Appeal Decision

Appeal Ref: APP/C3105/W/20/3263029

Brooklands, Church Street, Bodicote, Oxfordshire, OX15 4DR

- The appeal is made under section 78 of the Town and Country Planning Act 1990 against a refusal to grant planning permission.
 - The appeal is made by Mr Rowland Bratt against the decision of Cherwell District Council.
 - The application Ref 20/00841/F, dated 13 March 2020, was refused by notice dated 6 June 2020.
 - The development proposed is the erection of garage adjacent to approved dwelling and change of use of agricultural land to residential use.
-

DRAWING NUMBER:
4728/21H

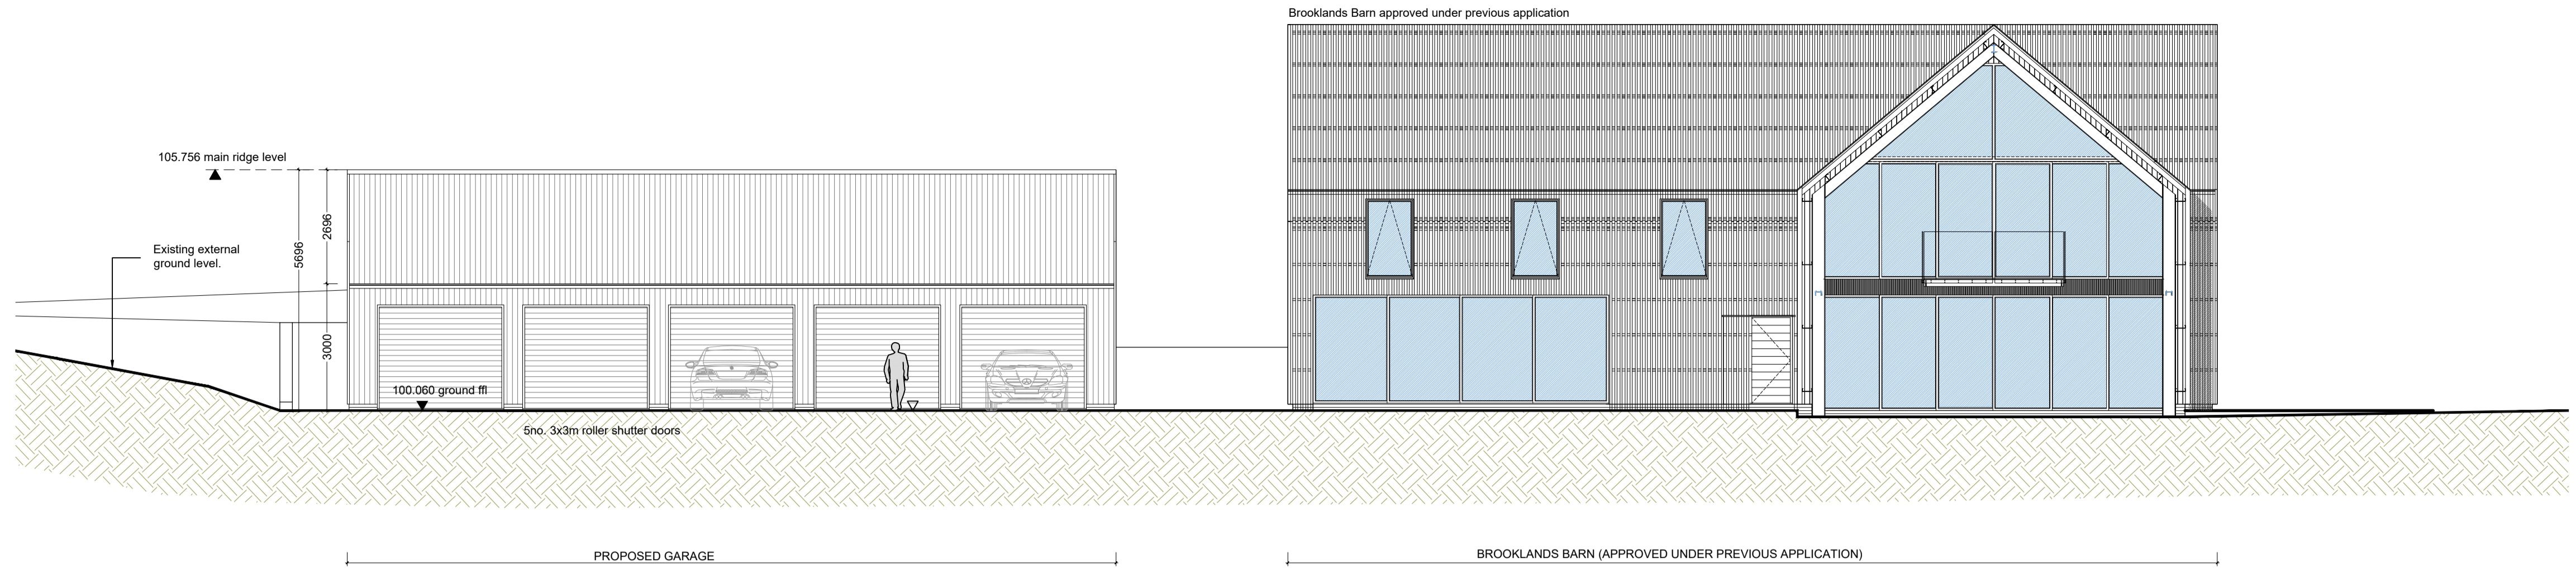
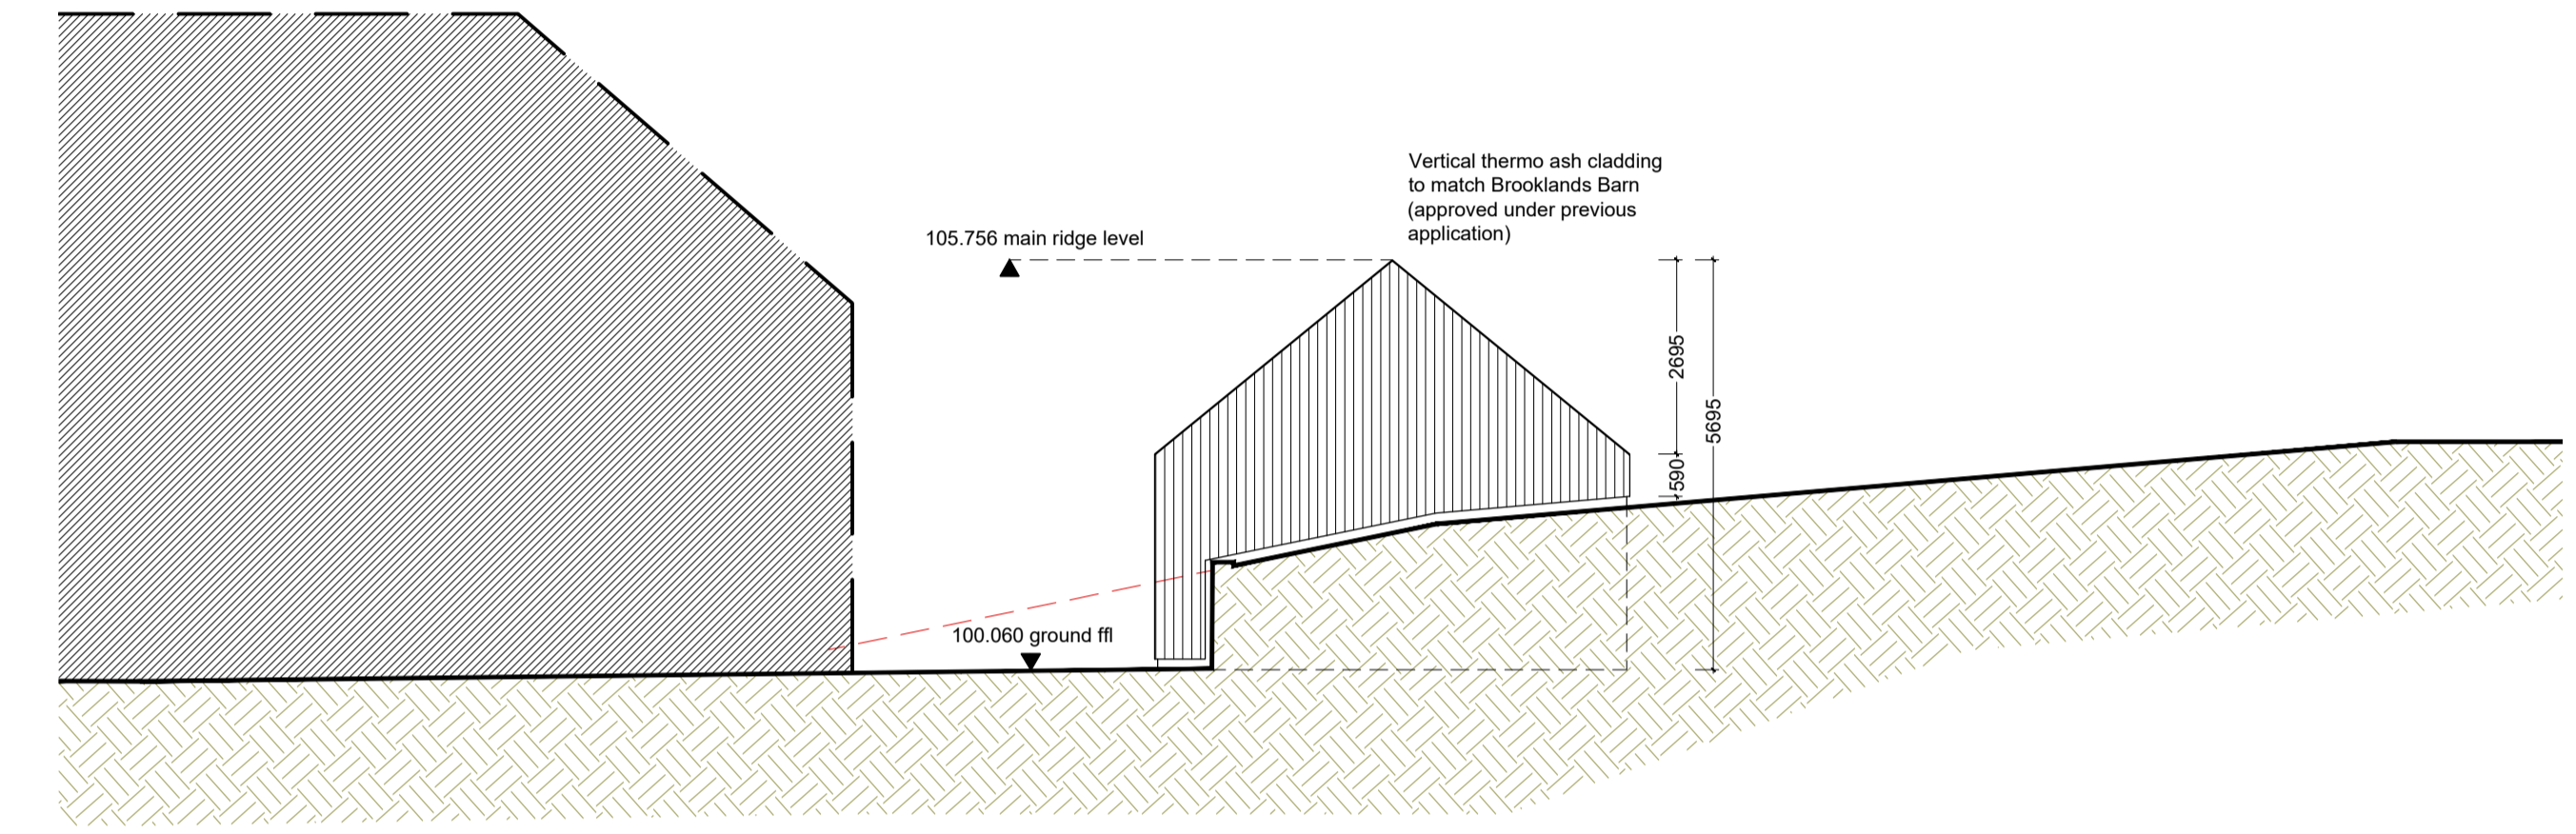
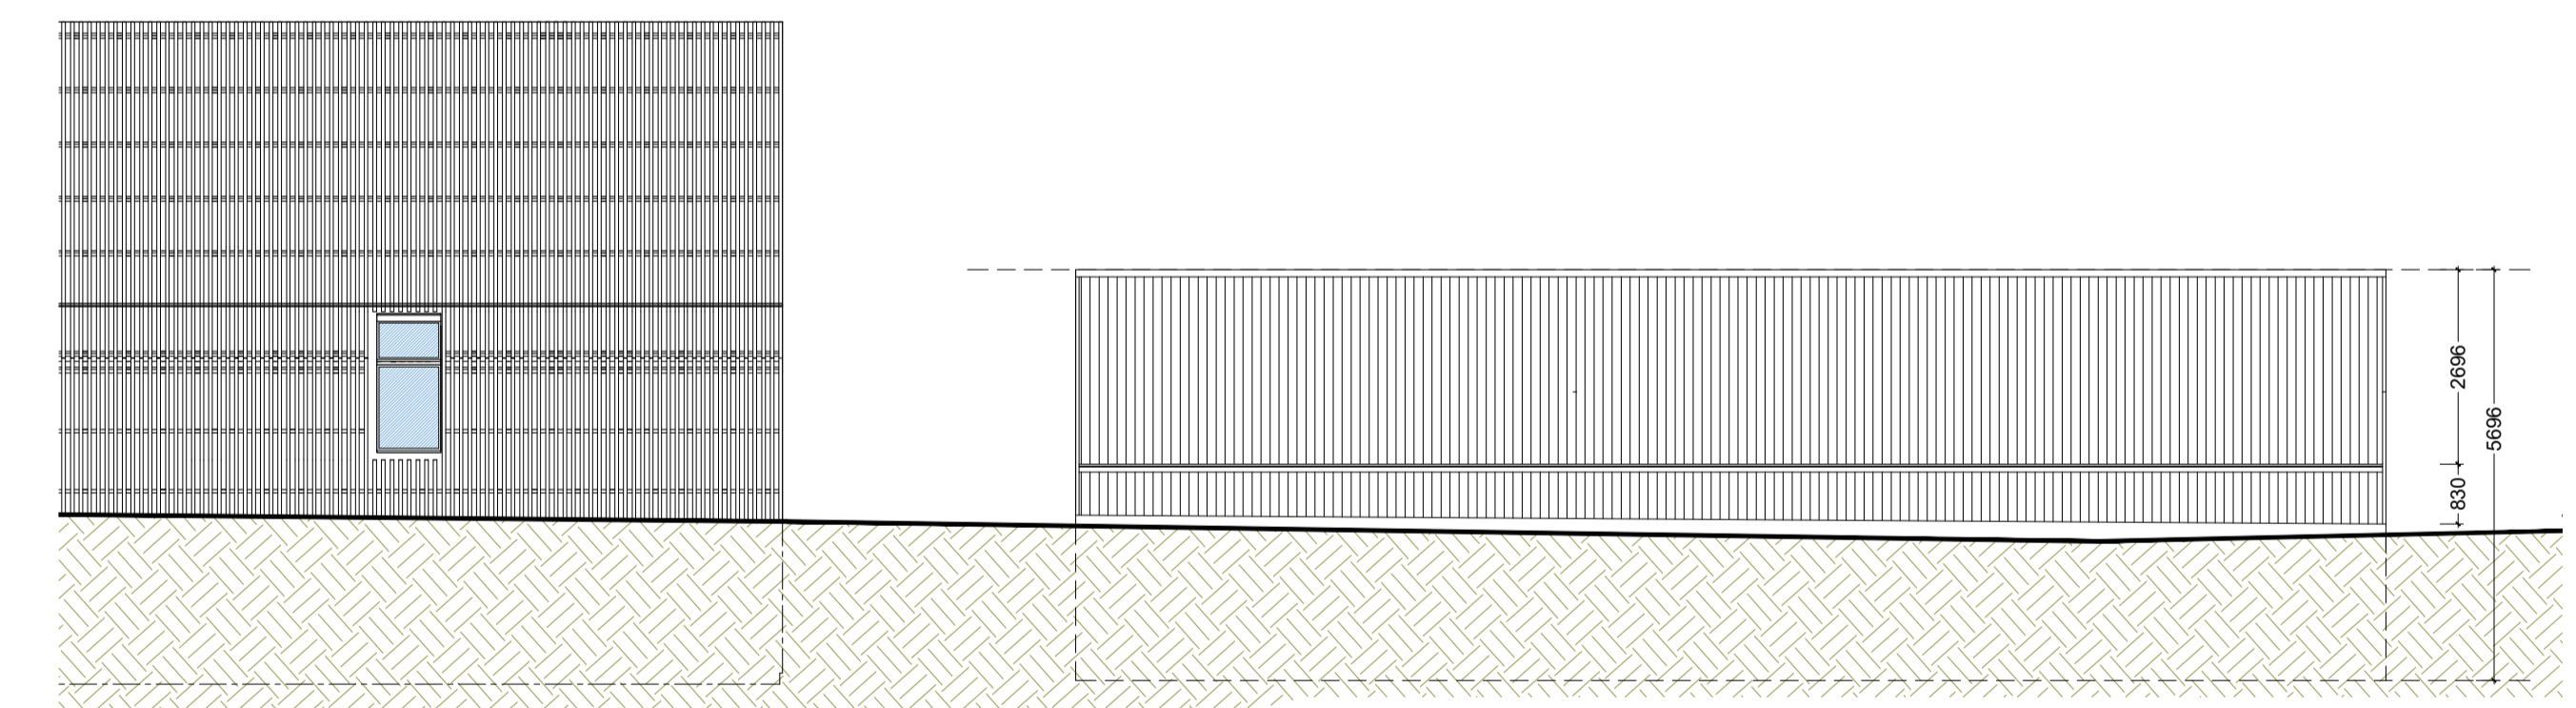
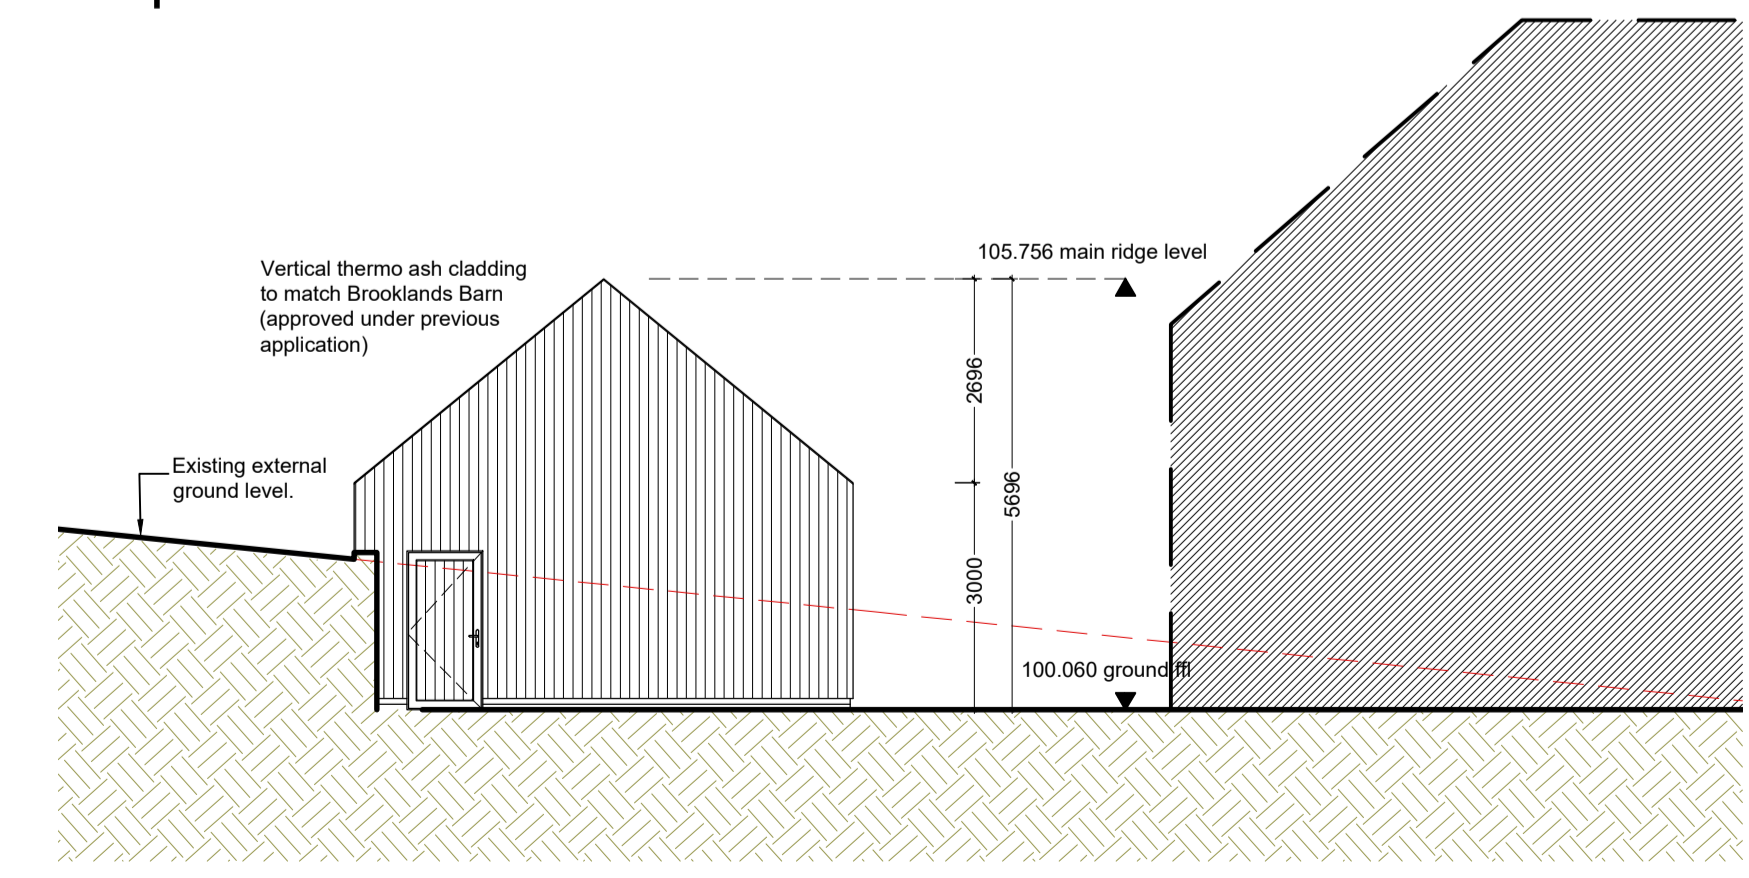
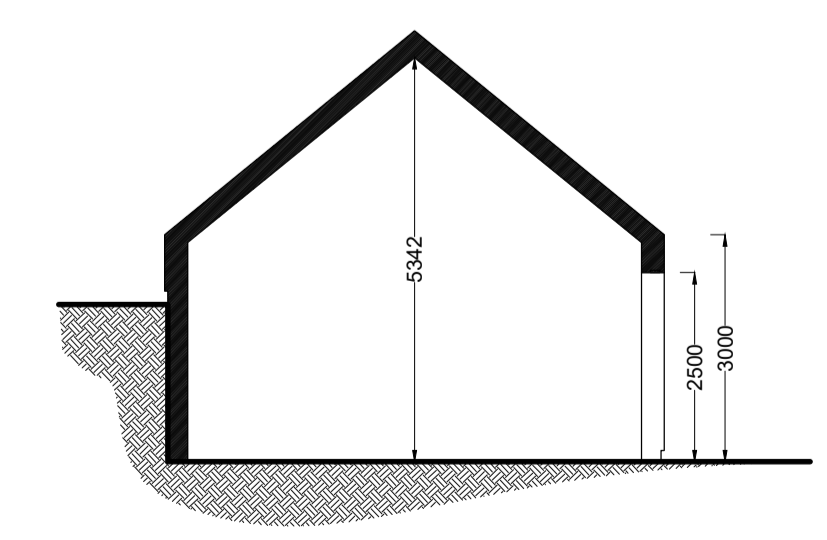
4. The appeal scheme seeks to introduce a single storey garage building to the north west of the dwelling, with a parking area provided to its front. Rather than being somewhat divorced from the dwelling, I find that it would share a close physical and visual relationship with it and for the most part would be viewed as such. The affinity between the two buildings would be reinforced by the use of matching materials. While I note the Council's concern over the commercial appearance of the proposal, given that the dwelling itself is formed from a converted building, this appearance would in my view be acceptable and would not be at odds with the character of the site and its surroundings.

5. The garage would comprise of five bays, two set aside for the storage of machinery for management of the surrounding land, and three for the parking of domestic vehicles. I note that it is somewhat larger than that which may ordinarily be associated with a dwelling, nonetheless the scale of the building would be subservient to what is a substantial dwelling. Moreover, the height of the garage would sit well below the dwellings' overall height.

6. I acknowledge that the existing structure at the site is visible from vantage points in the surrounding area; this would also be the case for the proposed garage. However, its visual presence would be mitigated by its close relationship to the dwelling, the use of the matching materials providing visual cohesion to the

appearance of the two buildings, as well as most significantly by the rising ground levels to the north of the site. It is against this increase in ground level which the development would be seen from the majority of views. From views from the east the converted building would screen the majority of views and from the south, from elevated ground, the garage would nestle into the ground levels of the site and the surrounding land. In this context, the building would appear as a subservient element, one which assimilates with the appearance of, and would appear significantly less prominent than, the main dwelling.

8. In isolation therefore, I find that the appeal scheme would not be harmful. However, I am particularly conscious that since the time of the refusal of the planning application, a further scheme has been submitted and has been granted planning permission by the Council for the erection of the same garage in a different position, i.e. further to the south in front of the dwelling itself. This is a matter to which I must have regard. The two garages would occupy discrete positions within the site and thus could both be constructed independently. This would lead to an increased quantum of built development at the site and result in visual clutter, harming the rural character of the location. I am conscious that the appellant highlights a willingness for the subsequently granted planning permission to be revoked. However, a planning permission can only be revoked following a specific process, which I am not aware has been undertaken. Furthermore, I am not satisfied that a planning condition could be used to prevent implementation of the already approved scheme.

9. In this case therefore, given that the appeal scheme could lead to the potential for the harmful proliferation of buildings at the site, I must find that it would result in a detrimental effect on the character and appearance of the area. Thus, it conflicts with saved policy C28 of the Cherwell Local Plan (adopted November 1996) and policies ESD13 and ESD15 of the Cherwell Local Plan – Part 1 (adopted 20 July 2015). Together, and amongst other things, these policies seek to ensure development is sympathetic to the rural context, that development respects landscape character and that proposals reinforce local distinctiveness.
